WEST SUSSEX COUNTY COUNCIL CONSULTATION

TO:	Arun District Council FAO: Stuart Corbey
FROM:	WSCC - Highways Authority
DATE:	21 March 2019
LOCATION:	Land at Watersmead Business Park Worthing Road Littlehampton BN17 6LS
SUBJECT:	LU/59/19/PL Installation of 5 No. 'vehicle-to-ground' lifts, HVAC plant units, a canopy cover over the associated service yard area for a temporary period of five years, installation of 3 No. level access doors, minor alterations to internal access road including widening works, creation of a new spur, provision of a pedestrian footbridge & associated lighting & drainage infrastructure provision.
DATE OF SITE VISIT:	N/A
RECOMMENDATION:	Advice
S106 CONTRIBUTION TOTAL:	N/A

Drawing Title
PROPOSED SITE BLOCK PLAN

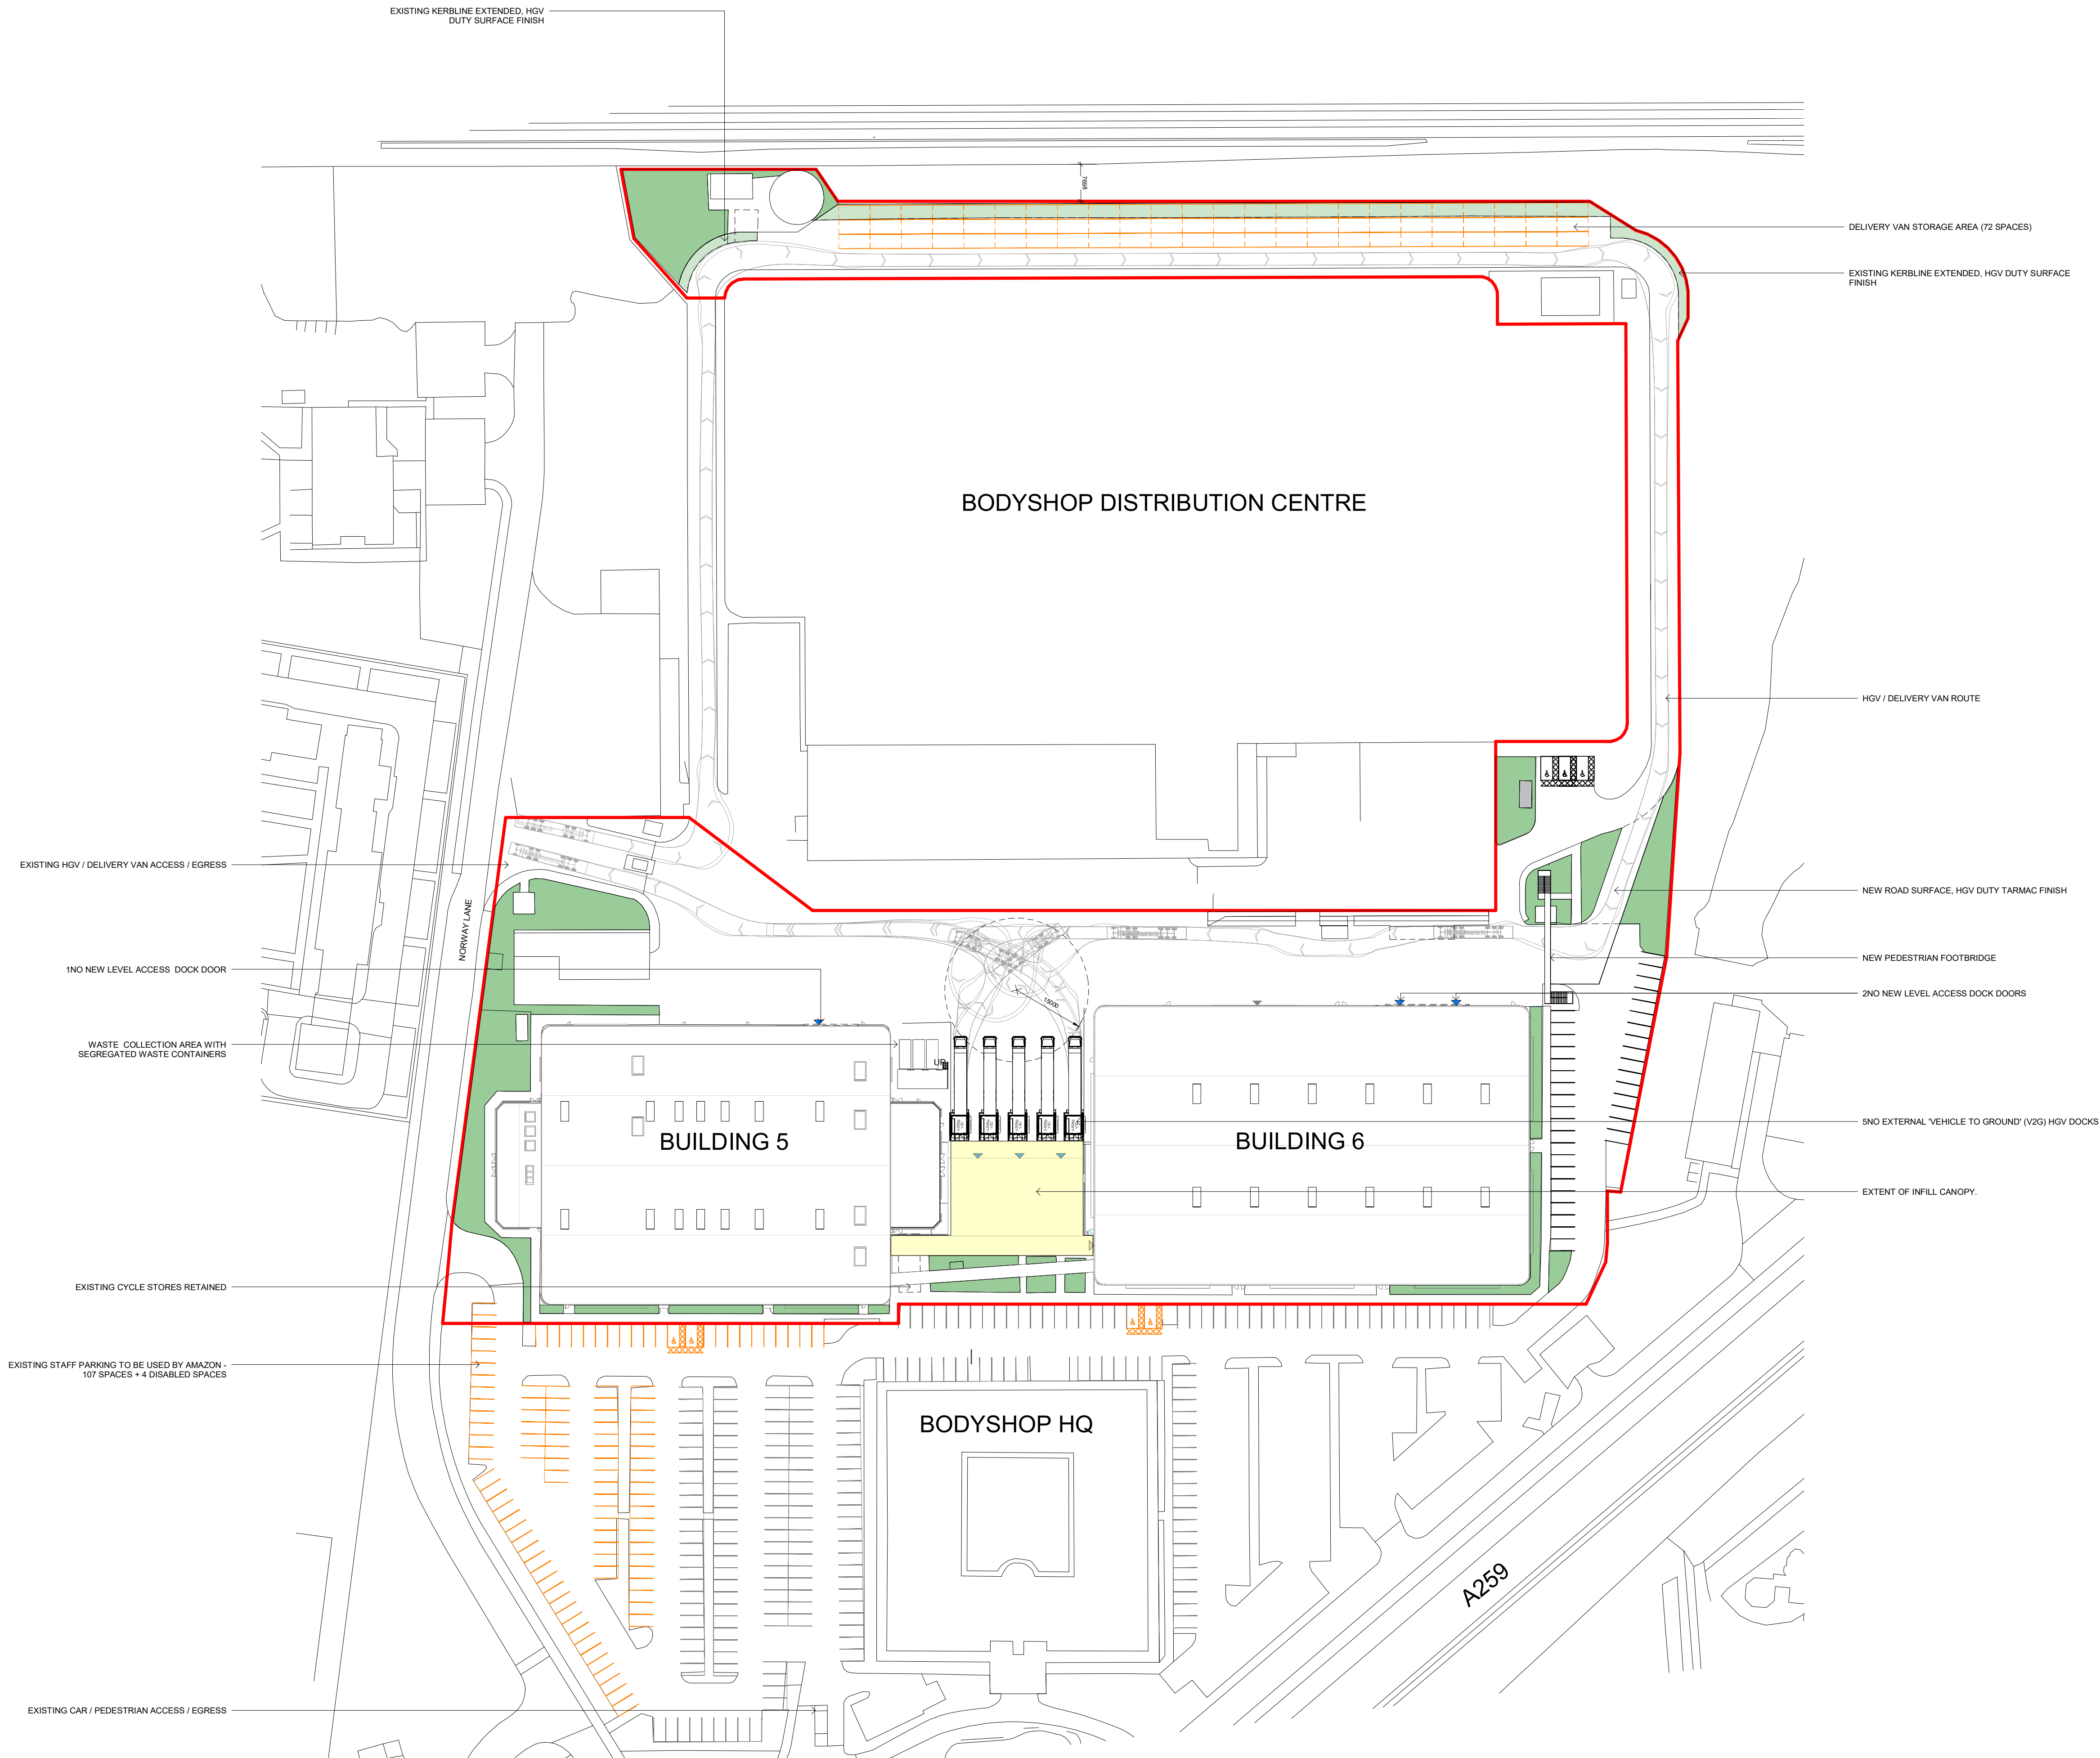
The LHA notes that the applicants' red edge on the site plan does not include the access to the west of Unit 3. The LPA should consider whether these access rights will remain in perpetuity.

The plans indicate that a van storage/parking area will be provided to the north of the site, accommodating 72 vans. These spaces appear to be of sufficient size to accommodate a standard van. No alteration to the existing staff or visitor parking is proposed, with the exception of the addition of three disabled parking bays within the site, which appear to meet minimum specifications as set out in Manual for Streets (MfS).

The plans indicate that a one-way access route will be provided through-out the site to enable the loading/unloading of goods vehicles. The applicant has provided swept path tracking throughout the site, demonstrating the manoeuvrability of a 16.5m articulated vehicle. Whilst the plans do demonstrate that the proposal is workable, albeit narrow, the plans indicate that HGVs will be required to carry out a specific manoeuvre in order to successfully negotiate the north western and north eastern corners of the site. This may even require the driver to carry out a multi-point manoeuvre in order to successfully negotiate the turn. The swept path tracking indicates that the vehicle may bump the kerb although it is not clear from the drawing whether this is the wheels of the HGV, or the chassis of the vehicle overhanging the kerb. Whilst this is not anticipated to result in a highway safety concern, the applicant may wish to consider further widening these corners to facilitate the manoeuvre. The swept path tracking demonstrates that HGVs can safely manoeuvre into the proposed loading area, exiting the site in a forward gear.
